# M25 junction 28 improvement scheme

TR010029

### 9.35 Applicant's comments on Local Impact Report submitted by Essex County Council

<b>Version</b>	<b>Date</b>	<b>Status of Version</b>
0	18 February 2021	Deadline 3a

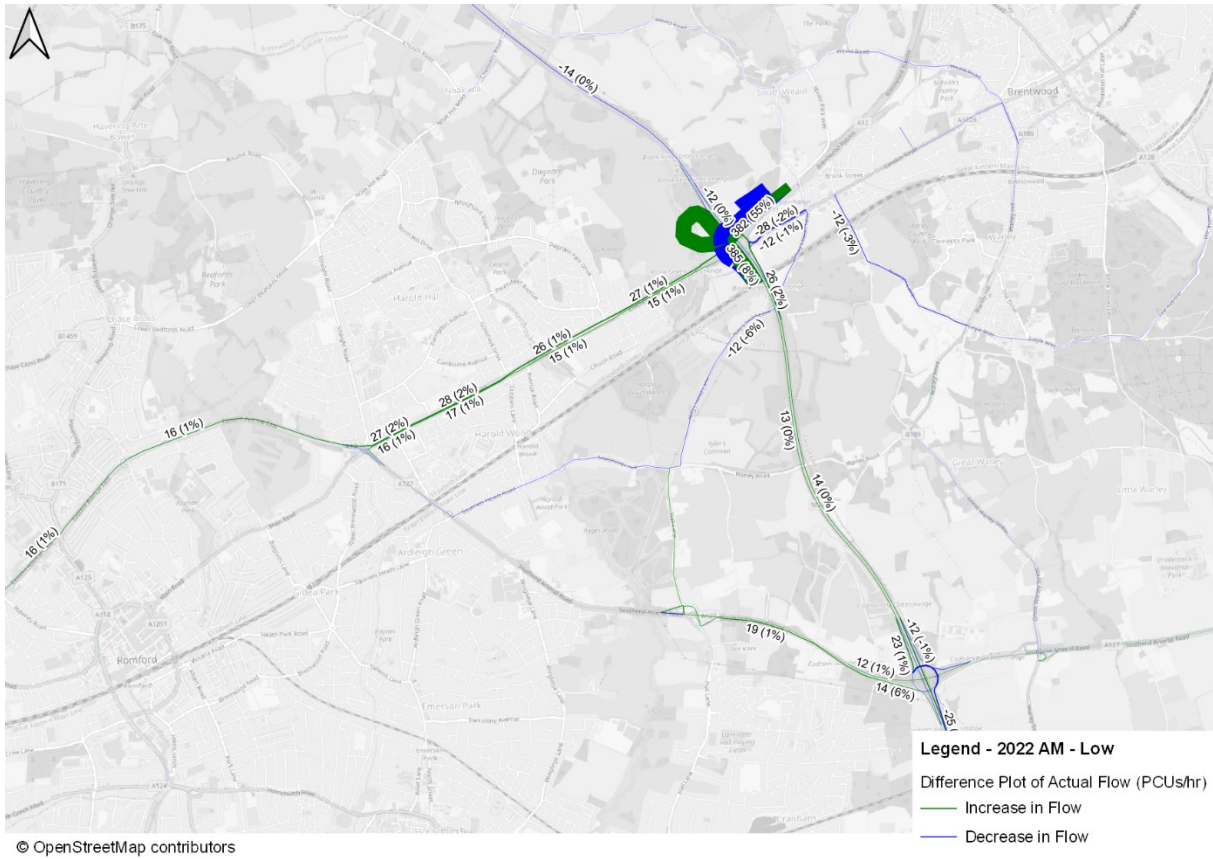
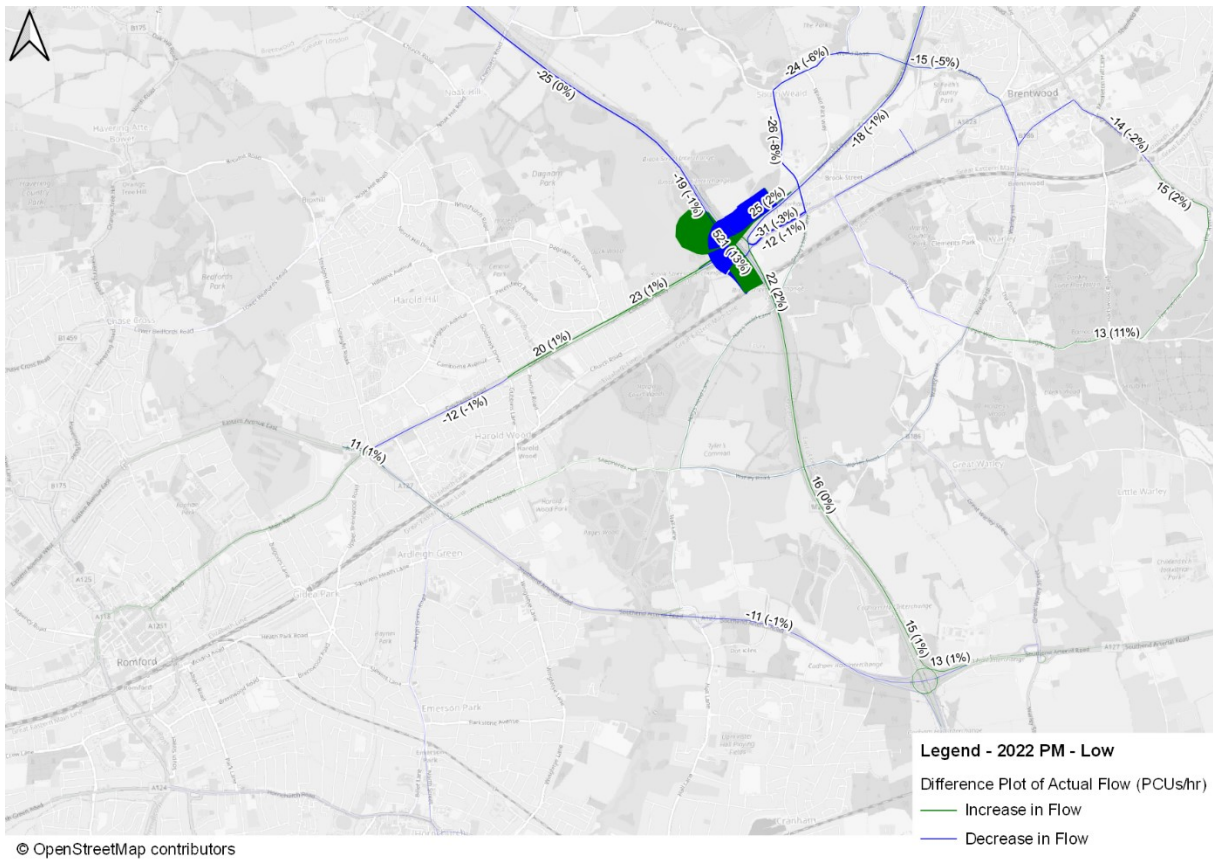
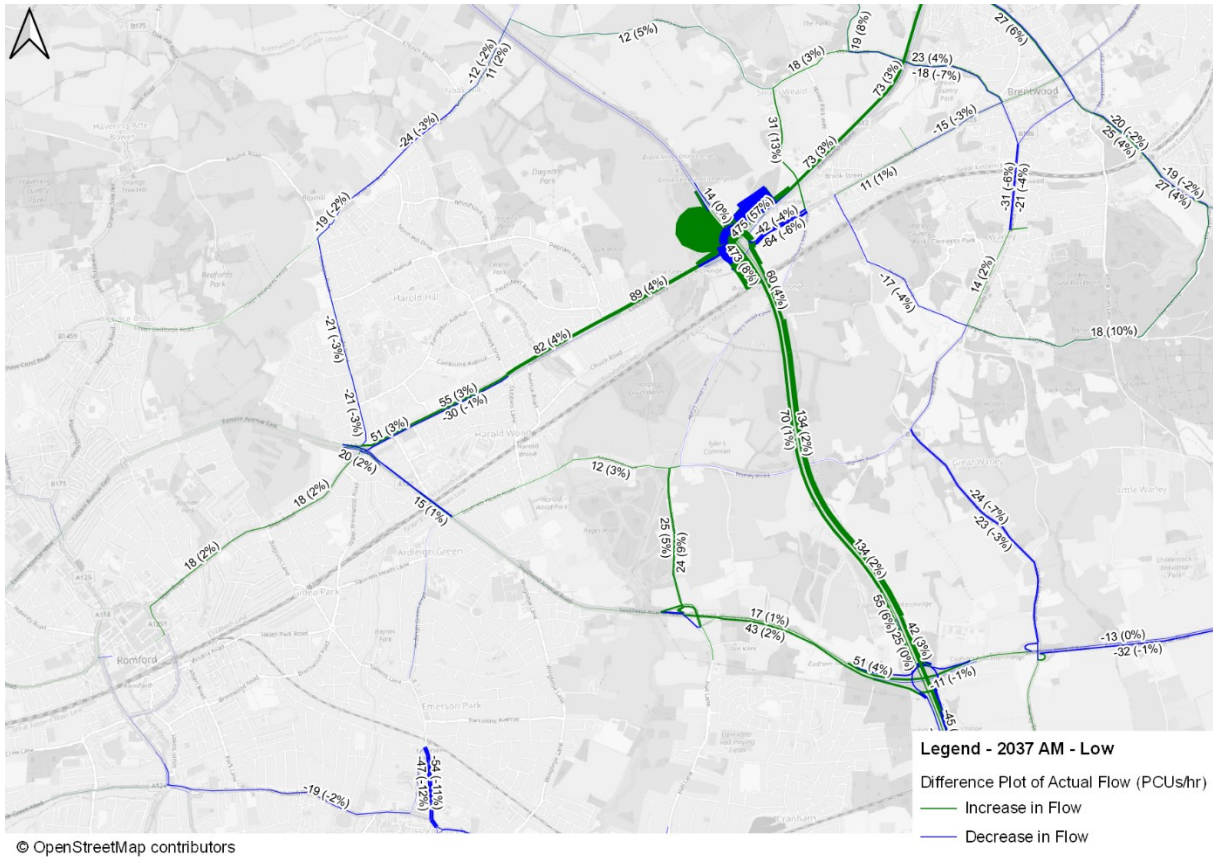
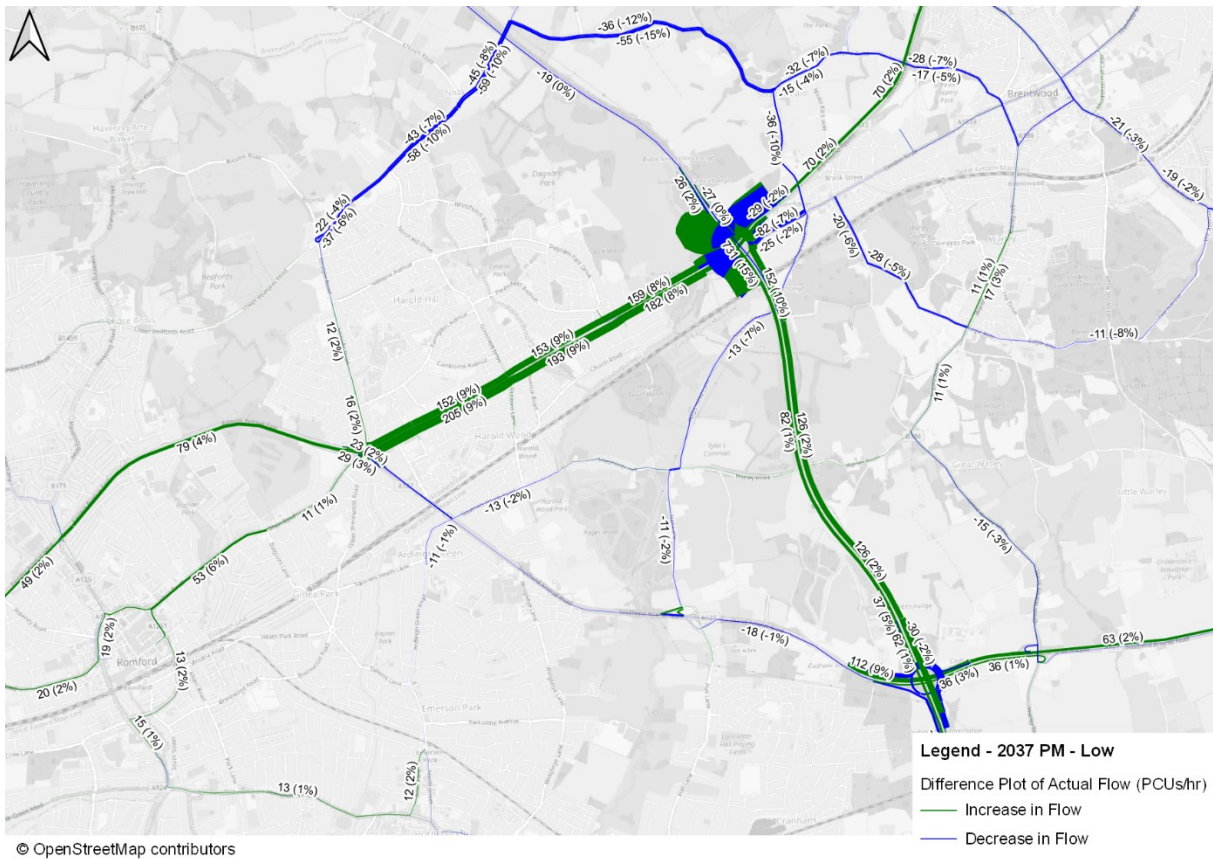
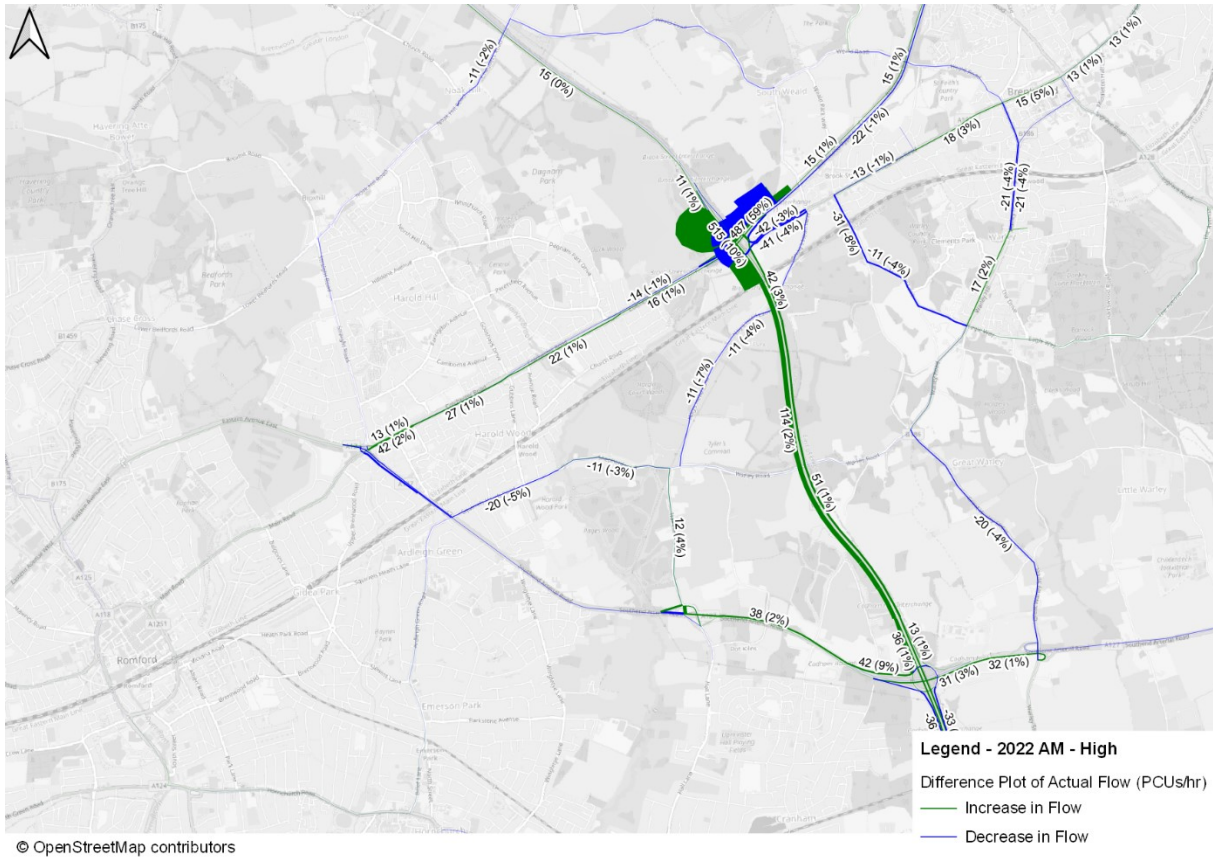
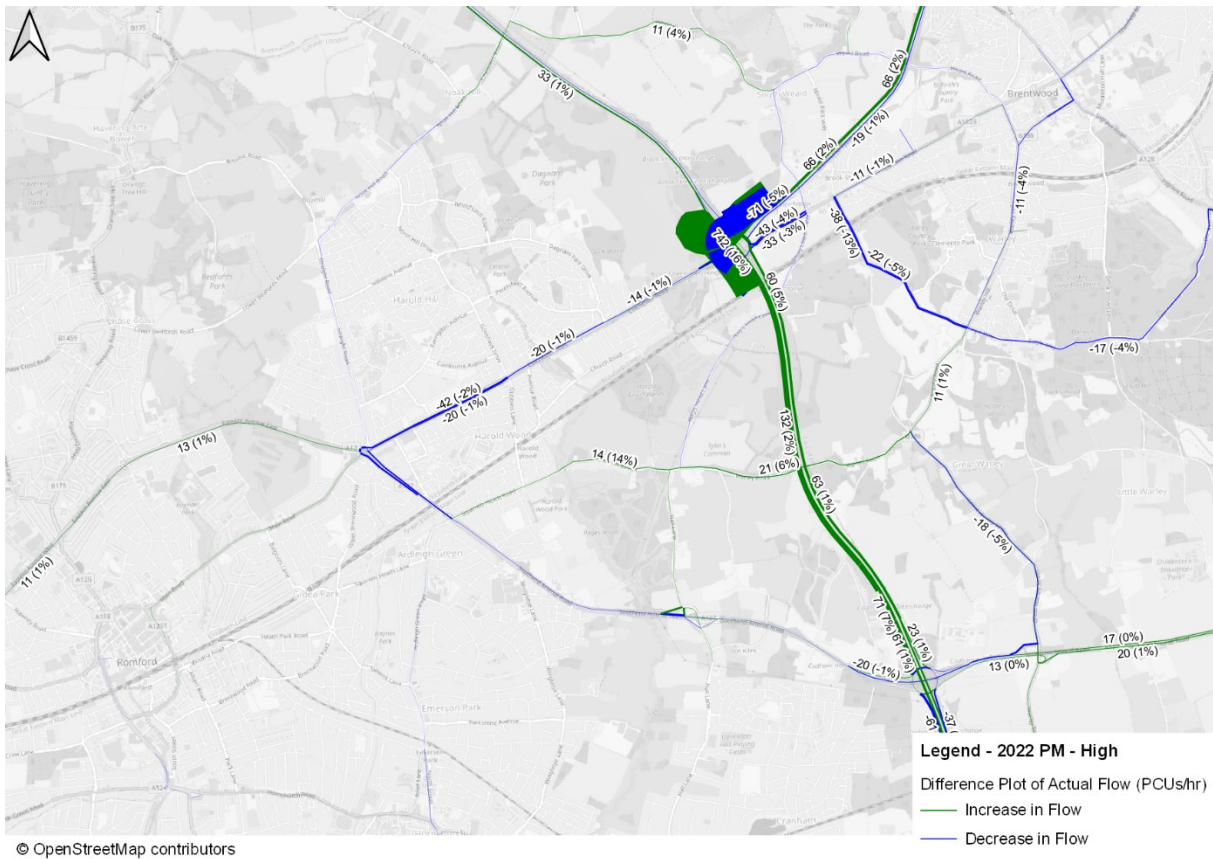
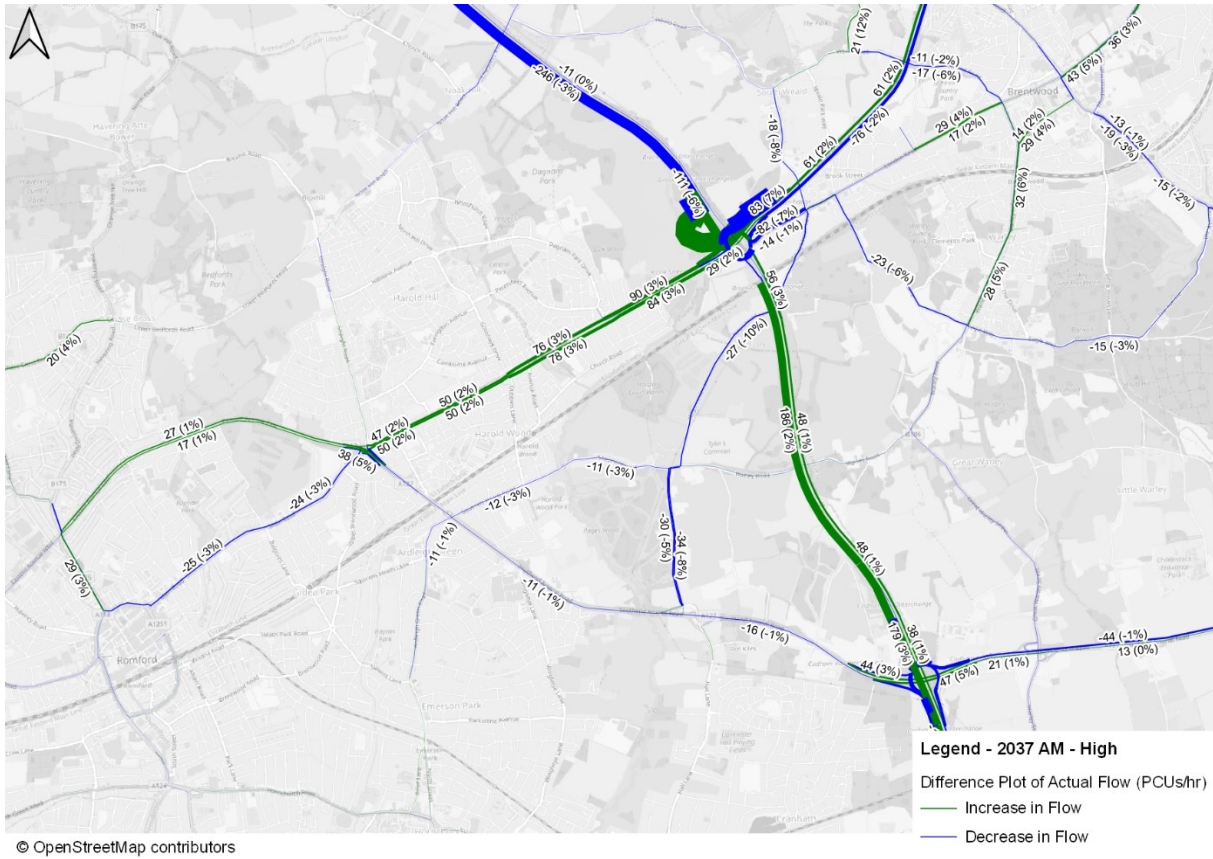
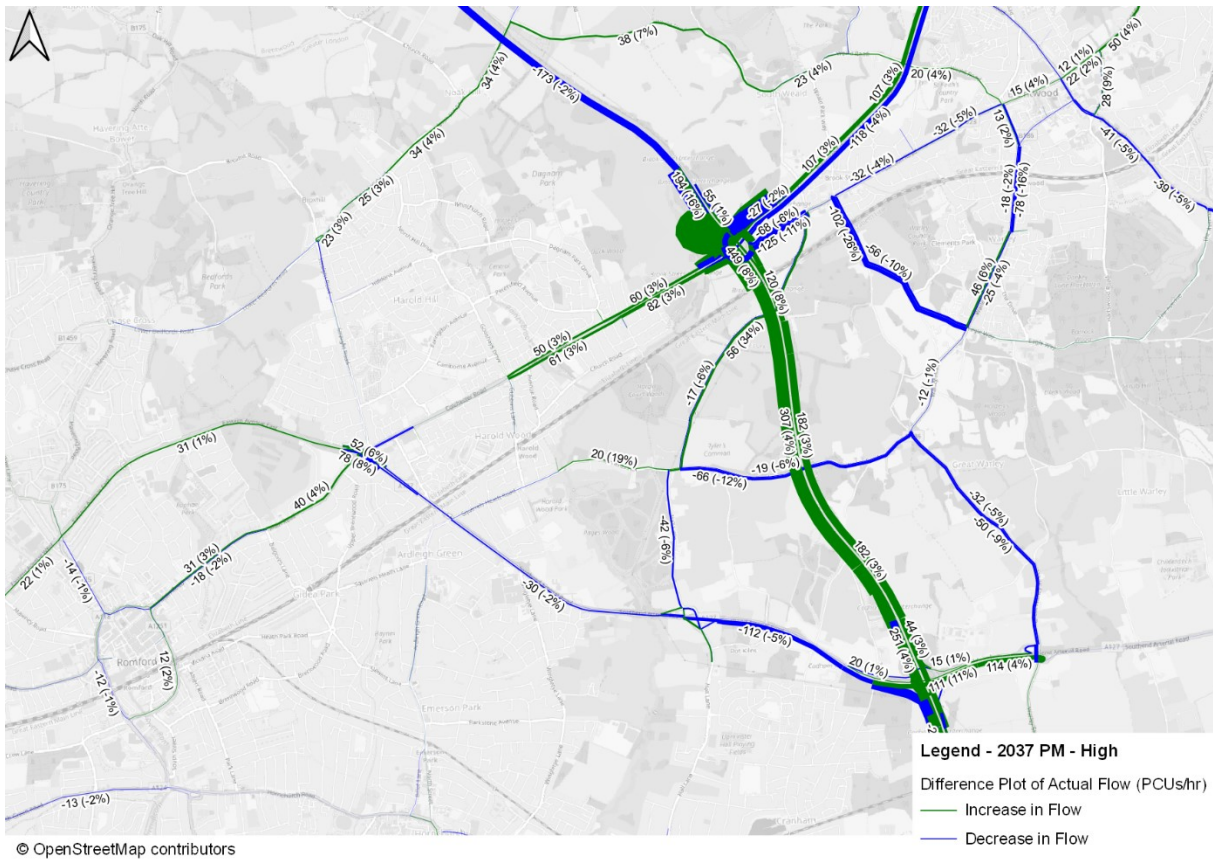
<b>Supplementary Report</b>		
3.1	<p>Brook Street</p> <p><i>In Section 5 the Applicant presents the results of the low and high growth scenarios. In the low growth scenario, the changes between the DS and DM appear consistent with the core scenario but of lower magnitude. In the high growth scenario, the changes between the DS and DM appear consistent with the core scenario but of greater magnitude. A direct comparison with the core scenario is not possible as different statistics have been presented for the low growth and high growth scenarios.</i></p>	<p>The benefit to cost ratios (BCRs) for low and high growth scenarios are 2.73 and 4.21 respectively, based on capturing only the elements of the benefits forecast through DfT's TUBA software.</p>

Paragraph	Issue	Highways England's Response			
	<p>Nevertheless, the results are in line with expectations, although it would be useful for the applicant to confirm the BCRs for the low and high growth scenarios. In addition, we would like to understand why the delay on Brook Street is greater in the low growth DM scenario than in the high growth DM scenario in the 2037 PM peak hour in both the DM and DS scenarios? We would assume all approaches would have greater delays in the high growth scenario compared to the low growth scenario. These questions are included in the comments log.</p>		TUBA only	All Benefits (Level 1)*	All Benefits (Level 2)**
		Core Growth	4.10	4.02	4.21
		Low Growth	2.73	N/A	N/A
		High Growth	4.21	N/A	N/A
		<p>* includes accident savings, disruption during construction, greenhouse gas emissions, local air quality and noise</p>			
		<p>** includes reliability and wider impacts</p>

<p>The additional elements which have been modelled to develop the full Level 1 and Level 2 Core BCRs are unlikely to significantly change with the alternative growth scenarios and so it has not been considered proportionate to reassess these.</p>			
		<p>Delays on Brook Street are lower in the high growth scenario compared to the low growth scenario because the queue in the eastbound direction on Brook Street from Nags Head Lane signal junction blocks the junction 28 circulatory more often in the high growth scenario compared to the low growth scenario. As a result of this queue, it creates more gaps in the platoons of traffic on the roundabout, enabling traffic from Brook Street (westbound) to more easily join the roundabout in the high growth scenario compared to the low growth scenario. In contrast, due to less queuing in the eastbound direction on Brook Street in the low growth scenario, the Brook Street westbound traffic experiences higher delay joining the roundabout due to fewer gaps in the traffic flow on the roundabout compared to the high growth scenario. However, it should be noted that the overall junction delays are still lower in the 2037 PM peak low growth scenario compared to the 2037 PM peak high growth scenario for the respective Do minimum and Do something models.</p>
